Red Text = The El Paso County Comments Rev. 0

Green Text = The Engineer of Record answers on the El Paso County Comments Rev. 0 for Variance of Use project

PROJECT NAME:
**VARIANCE
OF LAND USE**

PROJECT ADDRESS:
1185 N Curtis Rd,
Colorado Springs, CO
80930

**SHEET NUMBER:**  
**S-2**

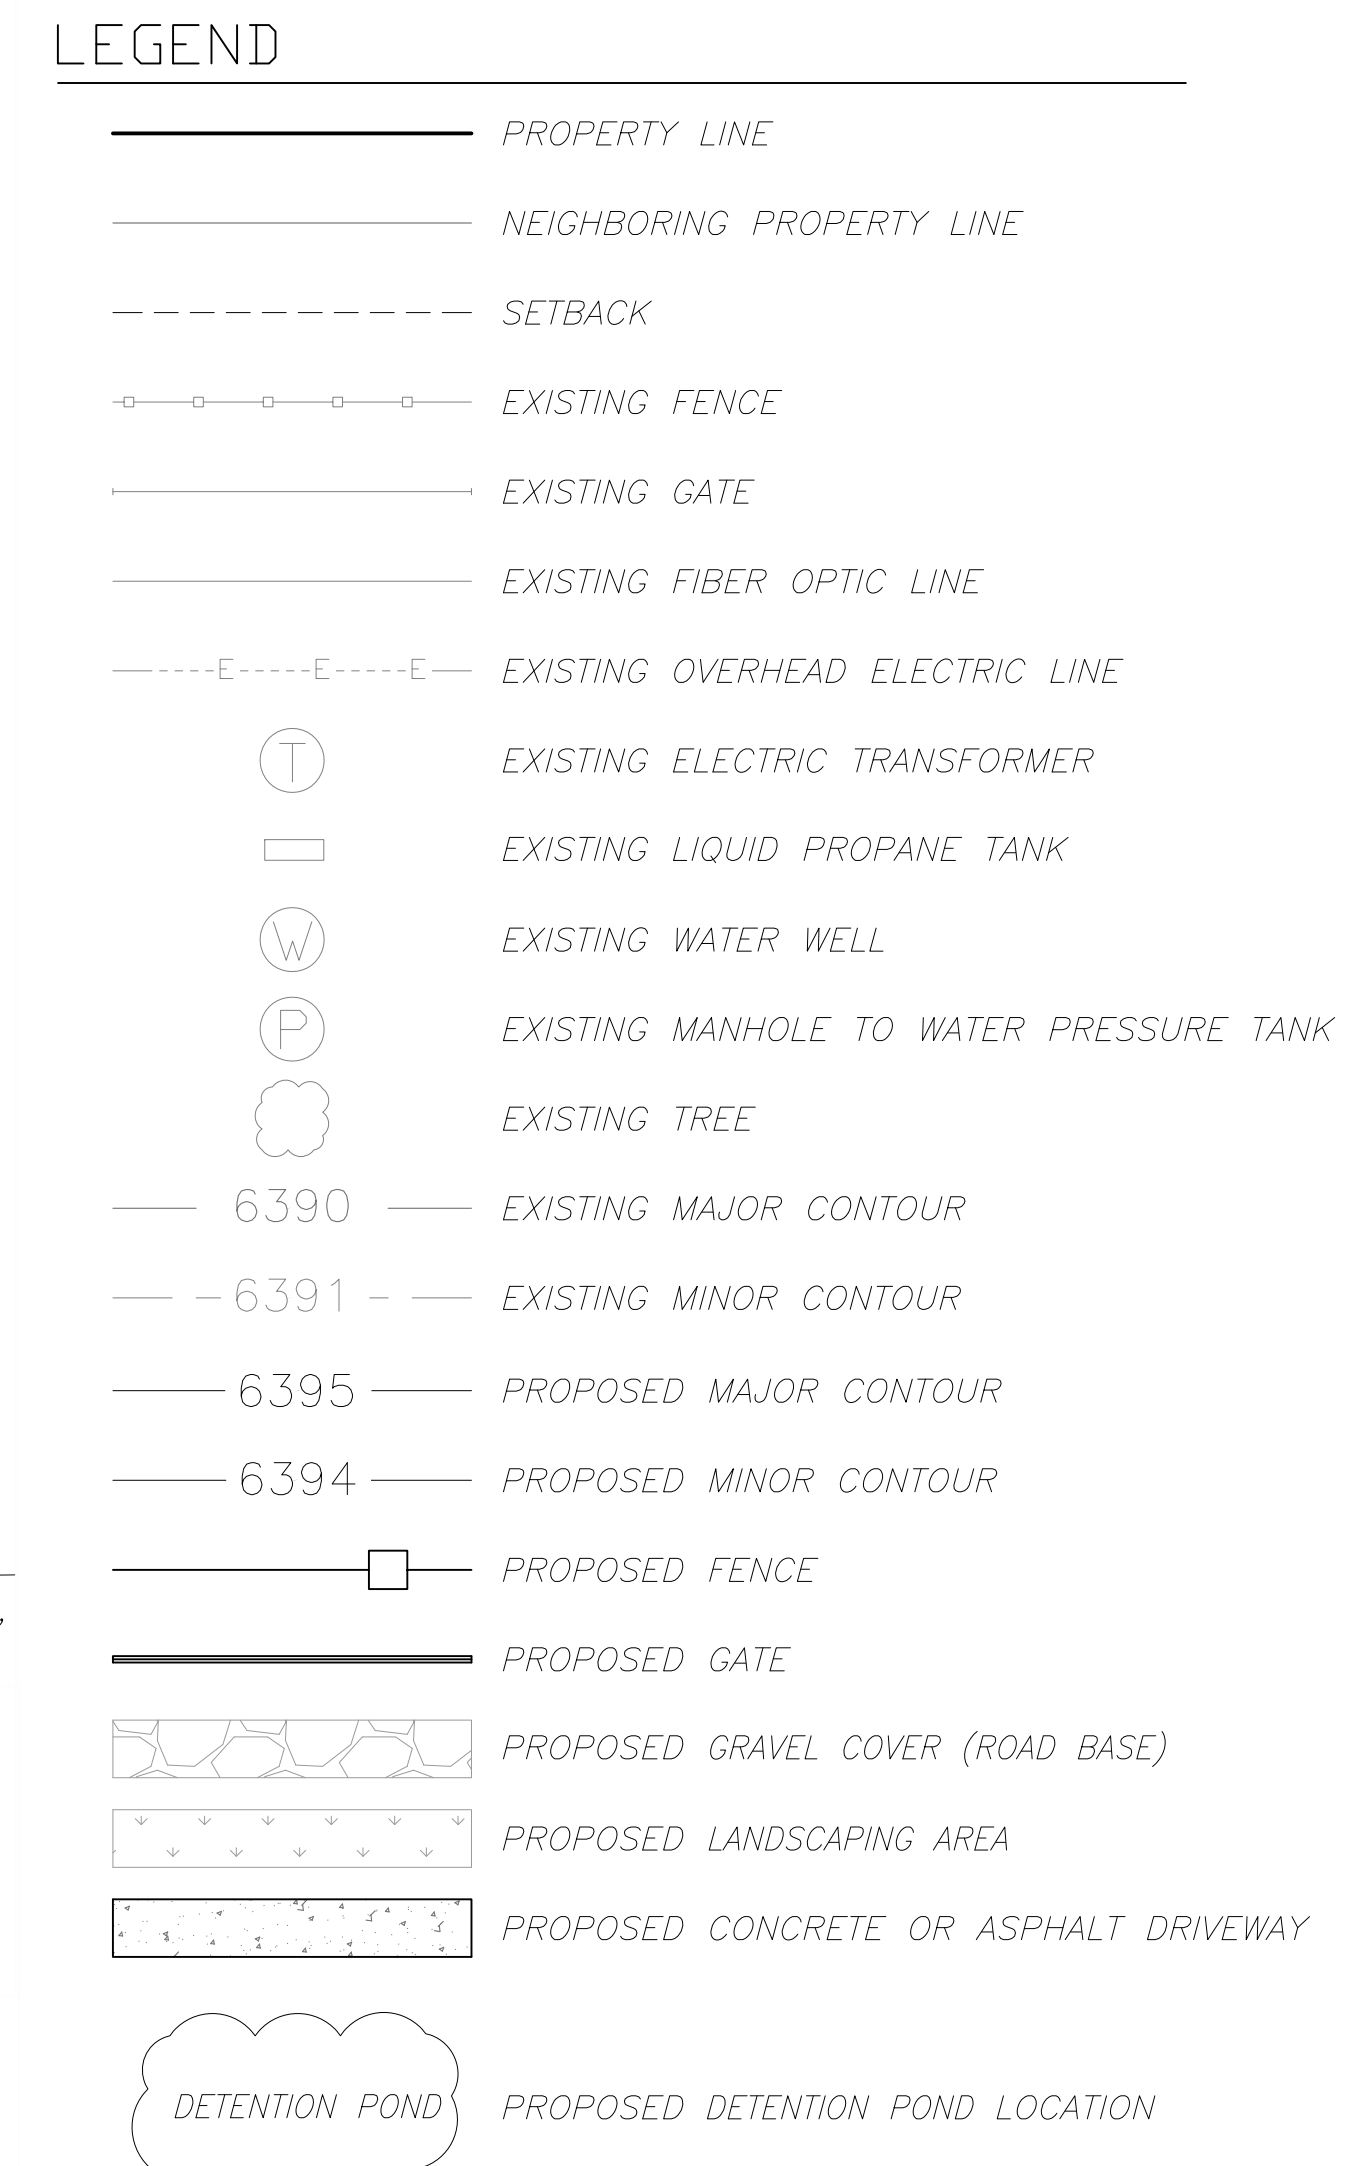
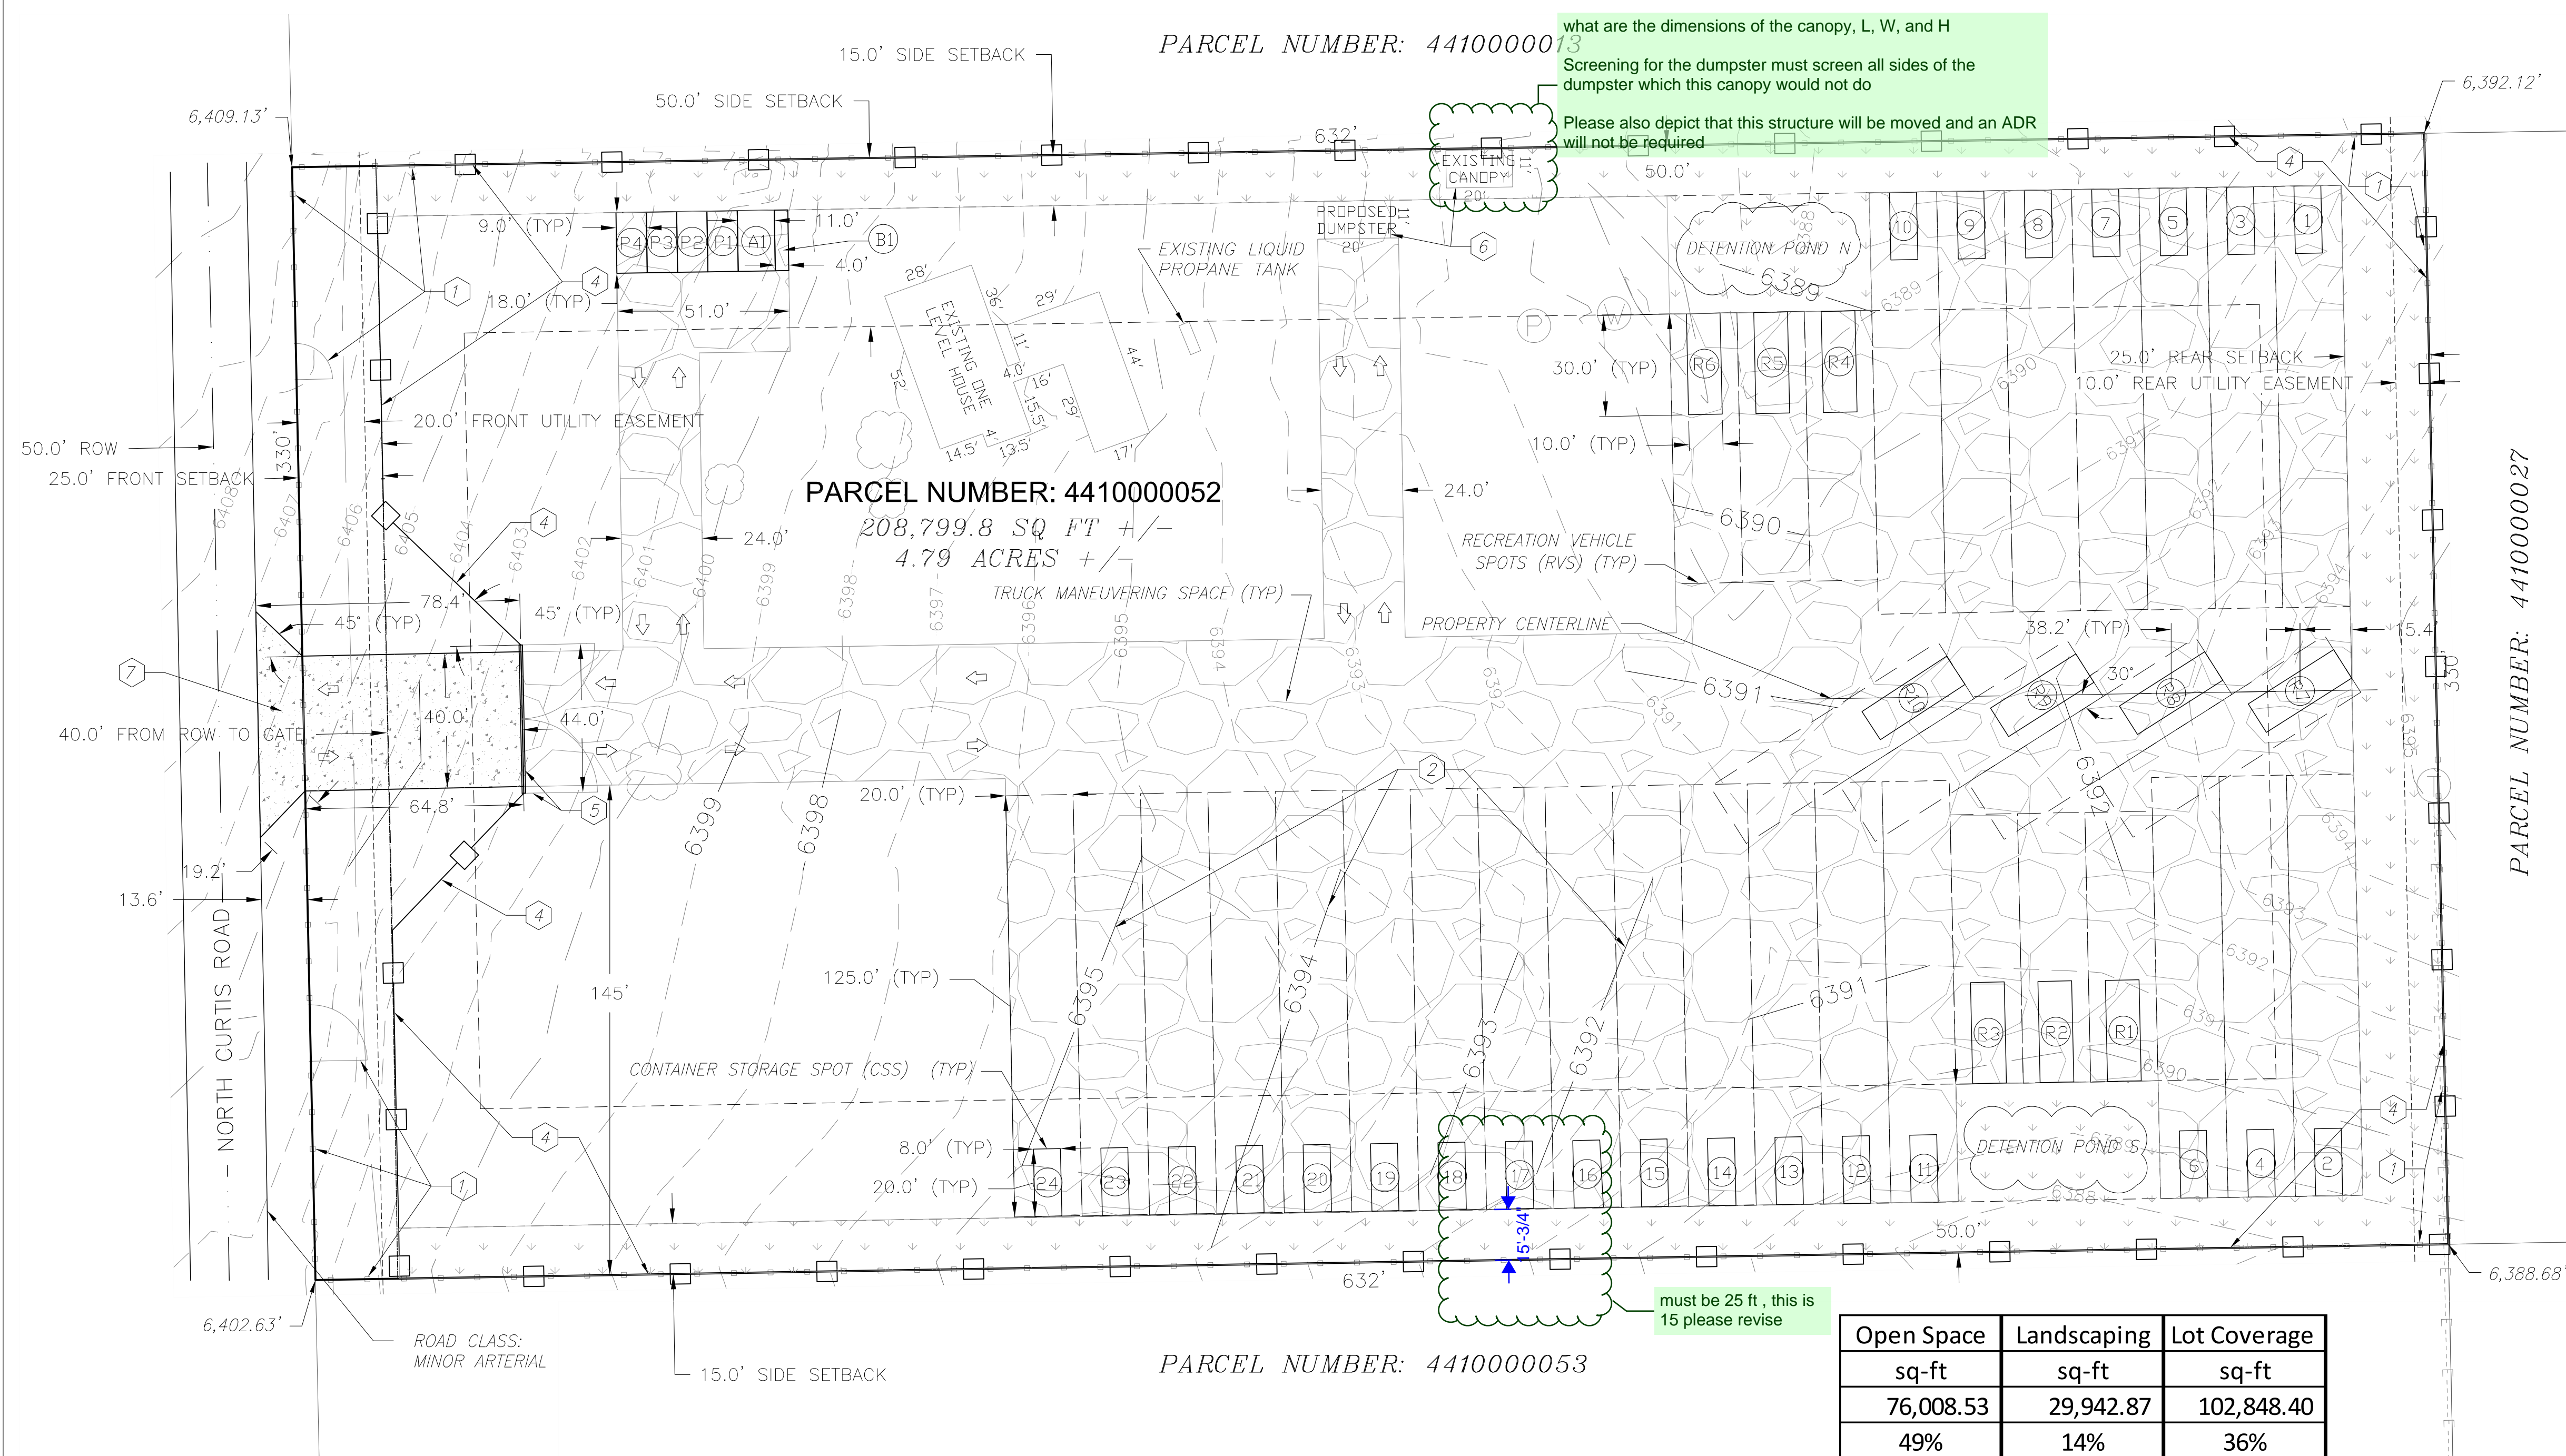
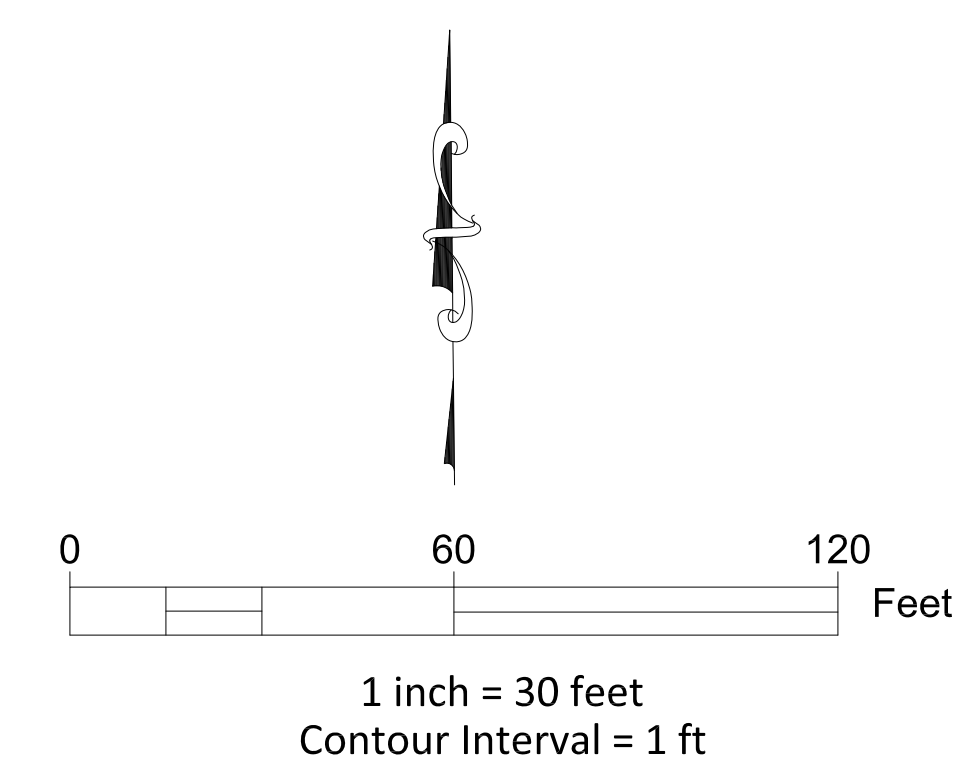
3. parking? if any, provide dimensions and number of spots

- 12. Location and screening of all dumpster(s) and loading area
 - ✓ The location and screening of dumpster is presented on Sheet #: S-2. Canopy moved to cover dumpster.

20. Show a driveway

23. Show and label entrance. Only one entrance can be permitted

27. Show all parking areas, drive aisles, RV parking pad sites by exact dimensions and layout. Show all gates with setback from road per LDC 30ft

29. Show and provide tabulated RV parking stall #s.

30. Plan for required water quality and detention structures in the site plan with required landscaping

Is the site will be unmaned with a 24/7 access gate
The entrance and gate should be set back further to ensure no long RVs or truck are sticking out into the road as they stop to open the gate. If two vehicles arrive at near the same time the current design does not have a provision for parking or staging off the roadway.
With the gate set back 30ft from the ROW the longest vehicle could be ~37ft or it stick out into the ROW.

2 way commercial entrance to an arterial road min 35ftmax 40ft width per ECM 2.4.1.E Please correct.

Call out entrance surface material type for first 50ft either asphalt mat or concrete

Where is the outside storage on this plan?

Please provide 1 bicycle space Section 6.2.5.F.1

Ensure the planned grading plan and detention pond layout will be functional. The ponds will need proper grading, spilldown areas and proper outlets. With the vehicle and container storage pads directly around the detention ponds this may not be feasible. The ponds may also need to be set back further from the property line to allow for a property outlet structure so no concentrated flow enter the adjacent property. Detailed GEC plan and drainage report will need to be provided with the SDP submittal.

- ✓ Container Storage Spots (CSS) will be located on each property line with the middle open for truck maneuvering. Each space is 45 ft long and 12 ft wide and has total 120 feet straight line clearance for pickup truck with container trailer as presented on Sheet #: S-2. The visual presentation of the container transport vehicle and container is shown below:

- ✓ The traffic circulation including all points of ingress/egress into the property are presented on Sheet #: S-2.
- 8. The layout and location of all off-street parking, loading and other vehicular use areas

- ✓ The layout and location of all off-street parking, loading and other vehicular use areas are presented on Sheet #: S-2
- 9. Location of all ADA parking spaces, ramps, pathways, and signs

✓ Driveway is shown on Sheet #: S-2.

✓ Show and label entrance is shown on Sheet #: S-2.

✓ Only one entrance is shown on Sheet #: S-2.

✓ All parking areas, drive aisles, RV parking pad sites, container storage spots, by exact dimensions and layout is shown on Sheet #: S-2. Show all gates with setback from road per LDC 30ft is shown on Sheet #: S-2.

✓ Tabulated RV parking stall #s is presented on Sheet #: S-2.

- ✓ Plan for required water quality and detention structures with required landscaping is presented on Sheet #: S-2.
